From: Laura Gibbons <Laura.Gibbons@arun.gov.uk>
Sent: 19 October 2021 12:16
To: Planning.Responses <Planning.Responses@arun.gov.uk>
Cc: Simon Davis <Simon.Davis@arun.gov.uk>
Subject: RE: Planning Consultation on: FG/163/21/PL

Application No: **FG/163/21/PL**

Site Address: The Chalet Littlehampton Road Ferring BN12 6PG

Description of Works: Development comprising marine workshop & boatyard, martial arts gym (Class E) & storage container compound (Class B8) to replace former glasshouses. This site is a Departure from the Development Plan & is in CIL Zone 3 (Zero Rated) as other development.

Figure 4: Proposed Drainage Scheme

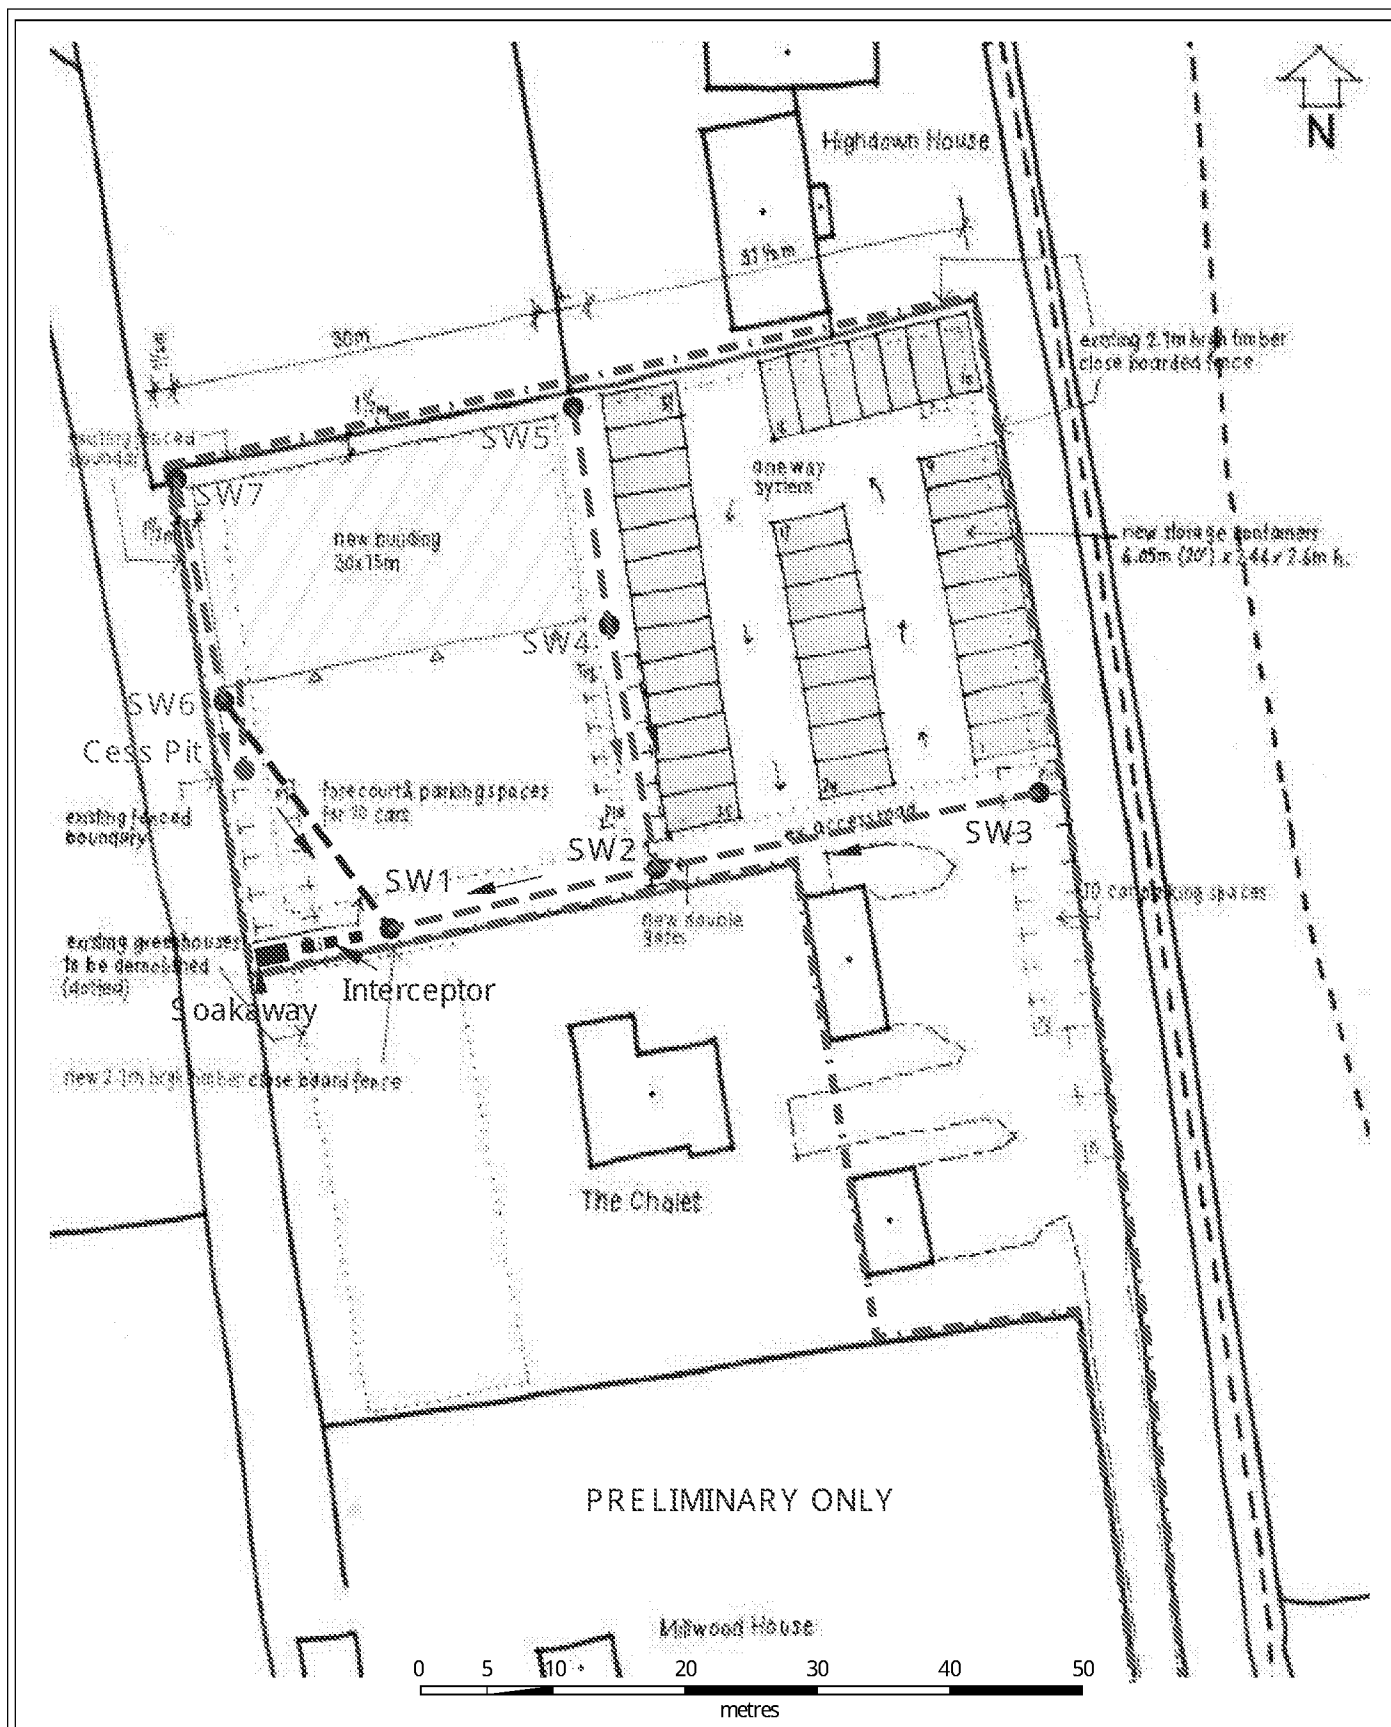
The application documents include a surface water drainage strategy. This strategy outlines that infiltration is proposed due to the anticipated ground conditions. This is acceptable in principle, especially as no other means of disposal exist. On site winter groundwater monitoring and winter infiltration testing will be required to support design.

We note that the strategy includes for one small soakaway and an interceptor. Surface water drainage treatment should occur at source and via a treatment train, the use of proprietary treatment devices should be seen as a last resort. We would suggest that consideration is given to the use of porous paving. Furthermore, we note that the proposed soakaway is located very close to the boundary, soakaways must be located at least 5m from buildings and highways and 2.5m from boundaries.

If you are minded to approve the application please ensure that the surface water drainage strategy is **not** listed as approved and apply the following conditions to ensure that the development is adequately drained and does not increase flood risk elsewhere.

“Development shall not commence, other than works of site survey and investigation, until full details of the proposed surface water drainage scheme have been submitted to and approved in writing by the Local Planning Authority. The design should follow the hierarchy of preference for different types of surface water drainage disposal systems as set out in Approved Document H of the Building Regulations, and the recommendations of the SuDS Manual produced by CIRIA. Winter groundwater monitoring to establish highest annual ground water levels and winter Percolation testing to BRE 365, or similar approved, will be required to support the design of any Infiltration drainage. No building / No part of the extended building shall be occupied until the complete surface water drainage system serving the property has been implemented in accordance with the agreed details and the details so agreed shall be maintained in good working order in perpetuity.”
